NSW RURAL FIRE SERVICE

Your reference: MP06_250 MOD9
Our reference: D16/4085

12 December 2016

Application for Modification MP06_250 MOD9 - Seaside Boulevard Fern Bay

SCALE	1: 1000	DRAWING TITLE	STAGES 18 & 19 DETAIL PLAN REV L
REVISION DATE	01/11/2016	DEVELOPMENT	PROJECT PLAN L
PLOT DATE	01/11/2016	DRAWN/CHKD BY	FERM BAY SEASIDE VILLAGE
DA NUMBER		IMC / AED	NELSON BAY ROAD, FERN BAY
		CC NUMBER	CLIENT
			RAWSON COMMUNITIES PTY LIMITED

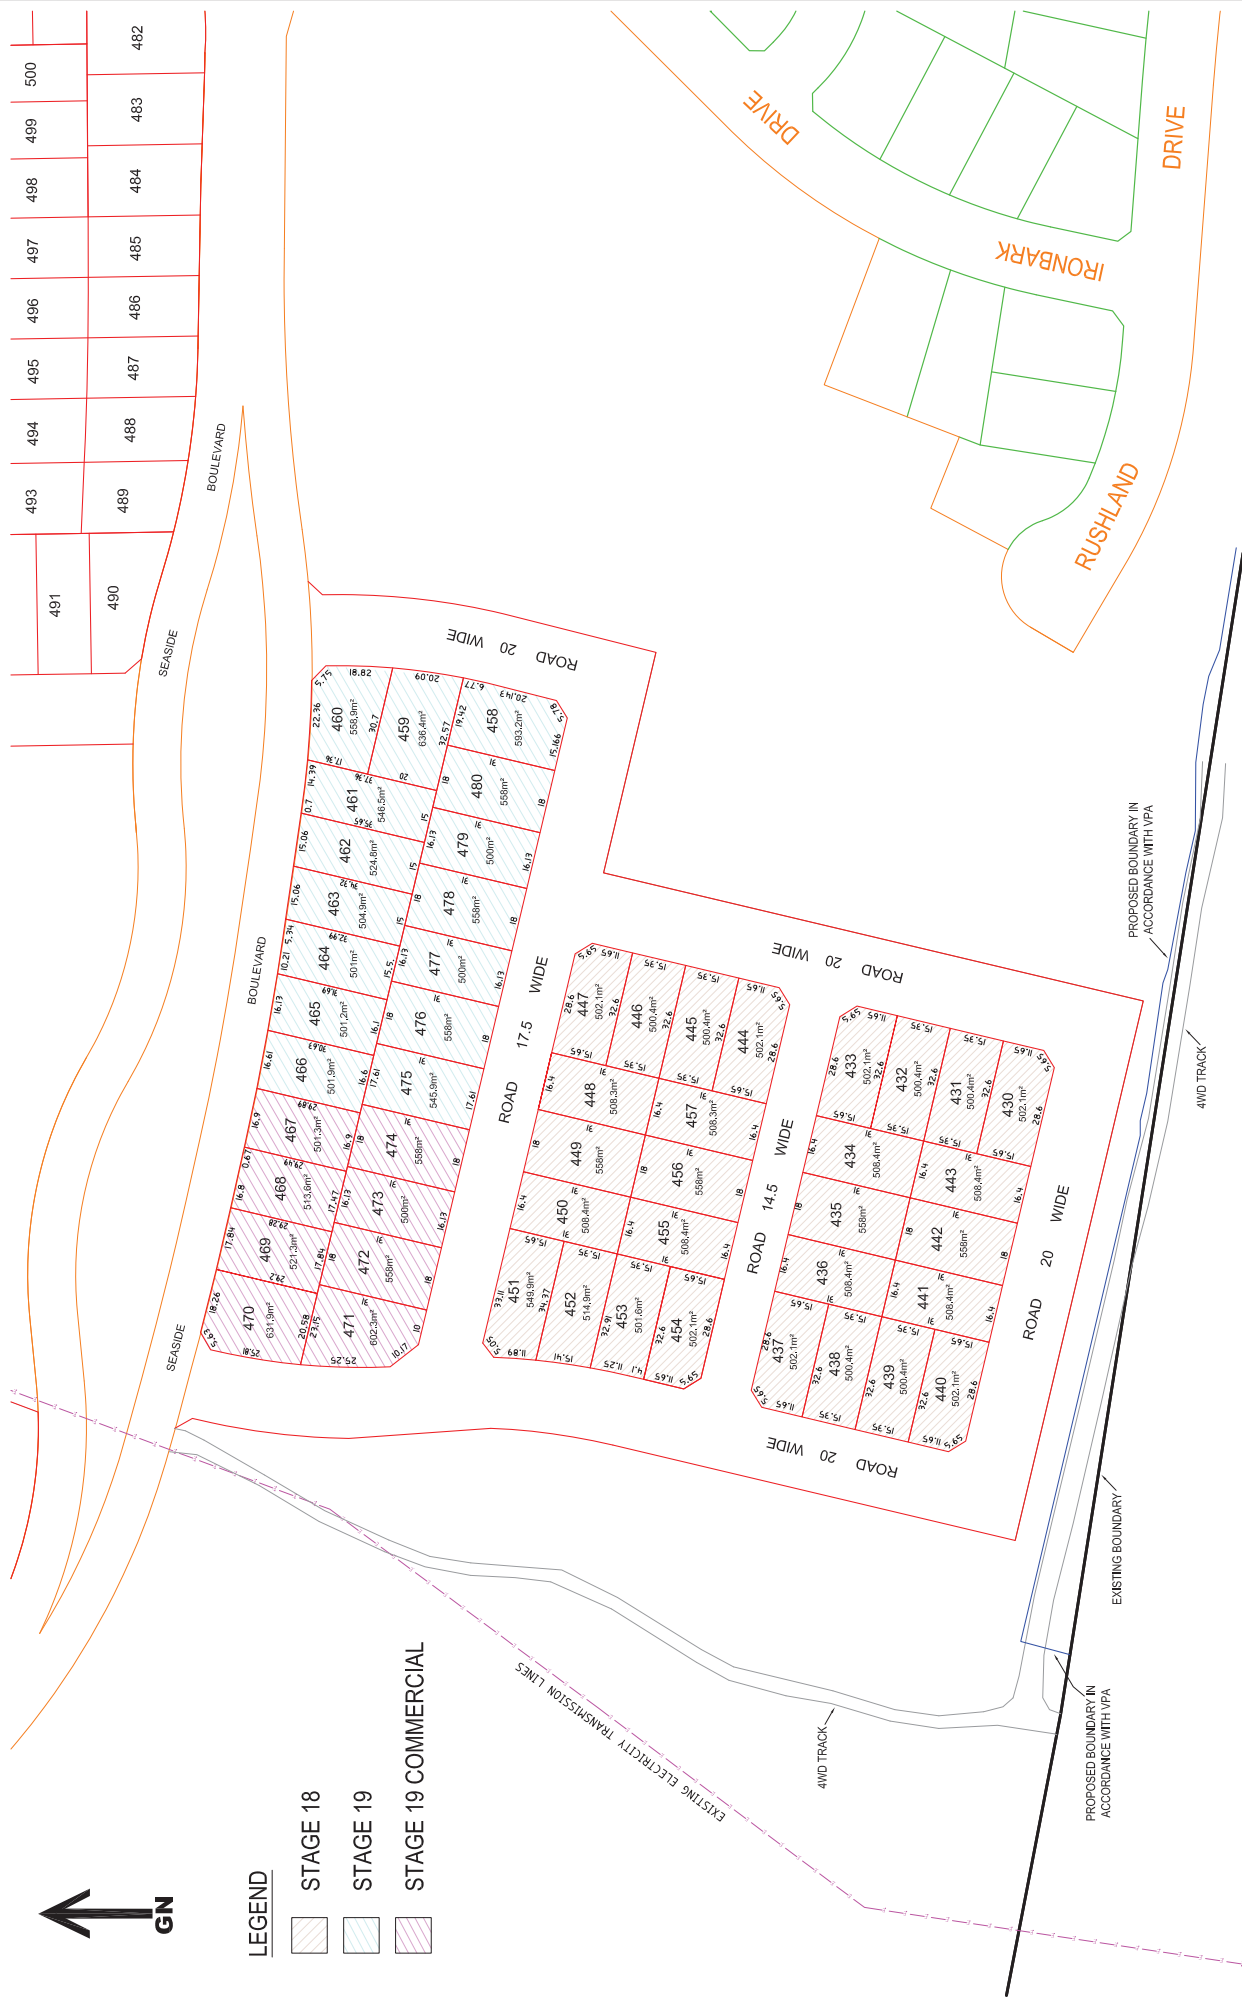
1. Make various changes to the stages 18, 19 and 20;
2. Relocate a proposed pumping stage station within stage 18; and,
3. Change a proposed secondary public road access to an emergency only access road.

The NSW RFS has reviewed the information provided and has no objection to proposed modifications 1 and 2 subject to the incorporation of the conditions listed below.

1. At the issue of subdivision certificate and in perpetuity the entirety of each residential lot shall be managed as an inner protection area (IPA) as outlined within section 4.1.3 and Appendix 5 of *Planning for Bush Fire Protection 2006* and the NSW Rural Fire Service's document *Standards for asset protection zones*.
2. At the commencement of building works and in perpetuity a 10 metre asset protection zone shall surround all structures associated with the proposed pumping station and shall be managed as an inner protection area (IPA) as outlined within section 4.1.3 and Appendix 5 of *Planning for Bush Fire Protection 2006* and the NSW Rural Fire Service's document *Standards for asset protection zones*.
